Title:
260 PROPOSED ELEVATION

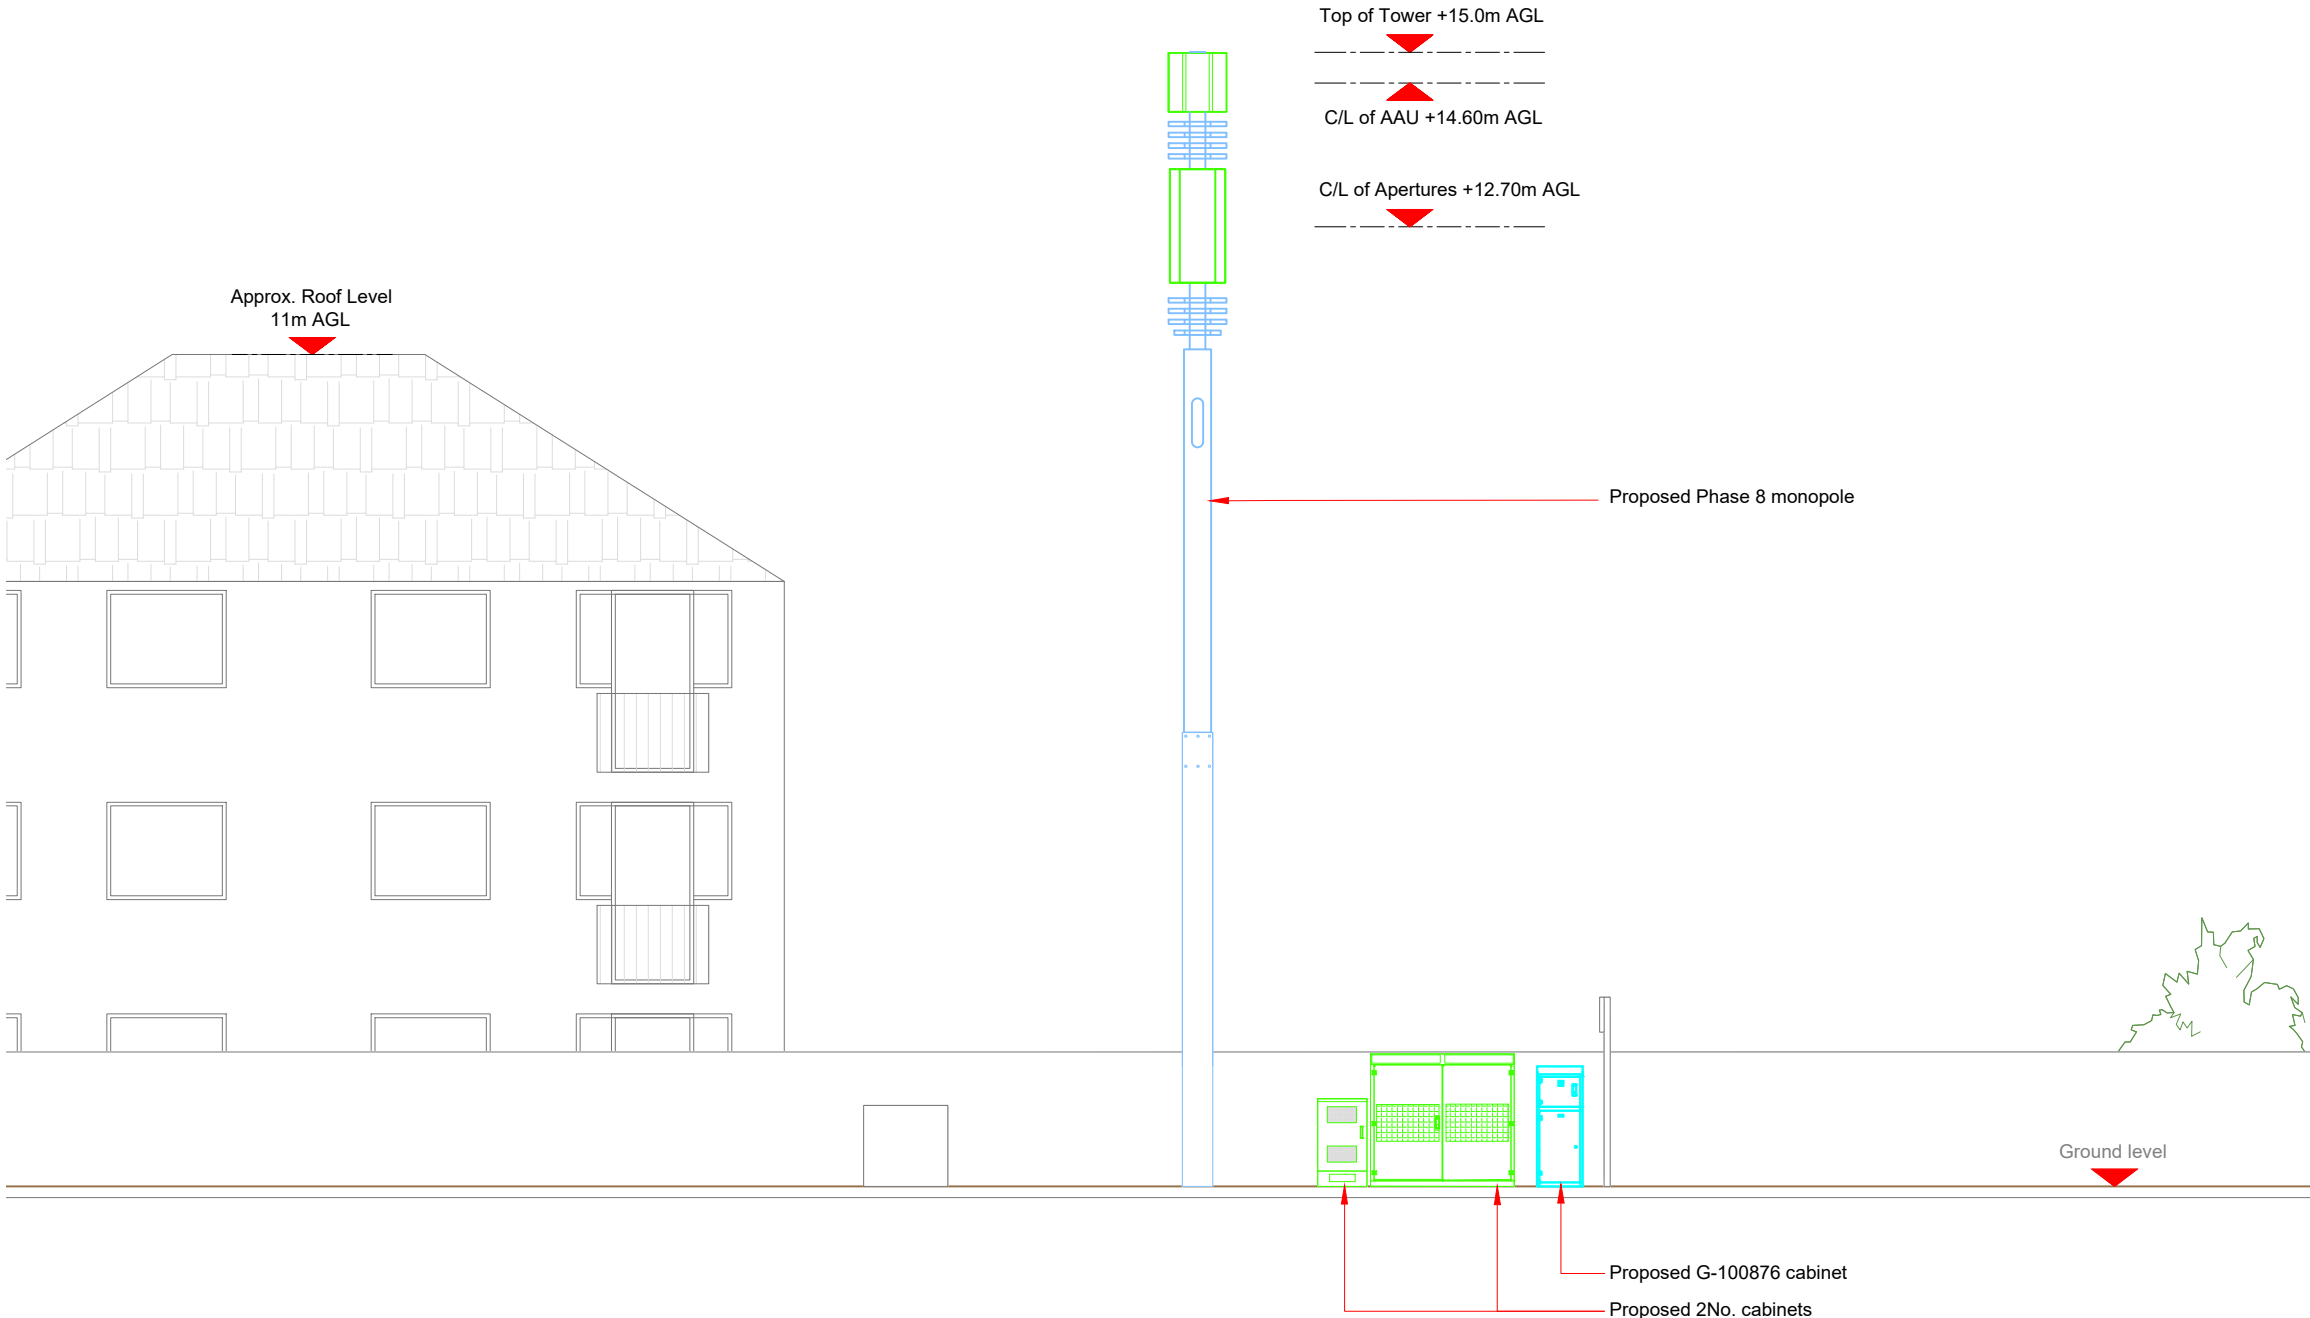
The proposed monopole is 15m high which is considerably less than what could fall under Part 16 and is also a slimmer design than previous monopoles have been. It is also noted that the immediately adjacent building is 3 storeys in height with a 3 storey building immediately opposite. There are also vertical features within the area such as lampposts and mature trees. However, the monopole would stand around 4m higher than the adjacent 3 storey building and higher still than the building opposite due to the land levels. The lampposts are also only relatively modest and predominantly stand on the opposite side of the road within the immediate surroundings of the site. The trees are also on a lower level than the site within a housing development which slopes away, down to the railway line.

As such, the proposed monopole would be very prominent within the streetscene and detrimental to visual amenity, contrary to Local Plan Policies D1 and GD1.
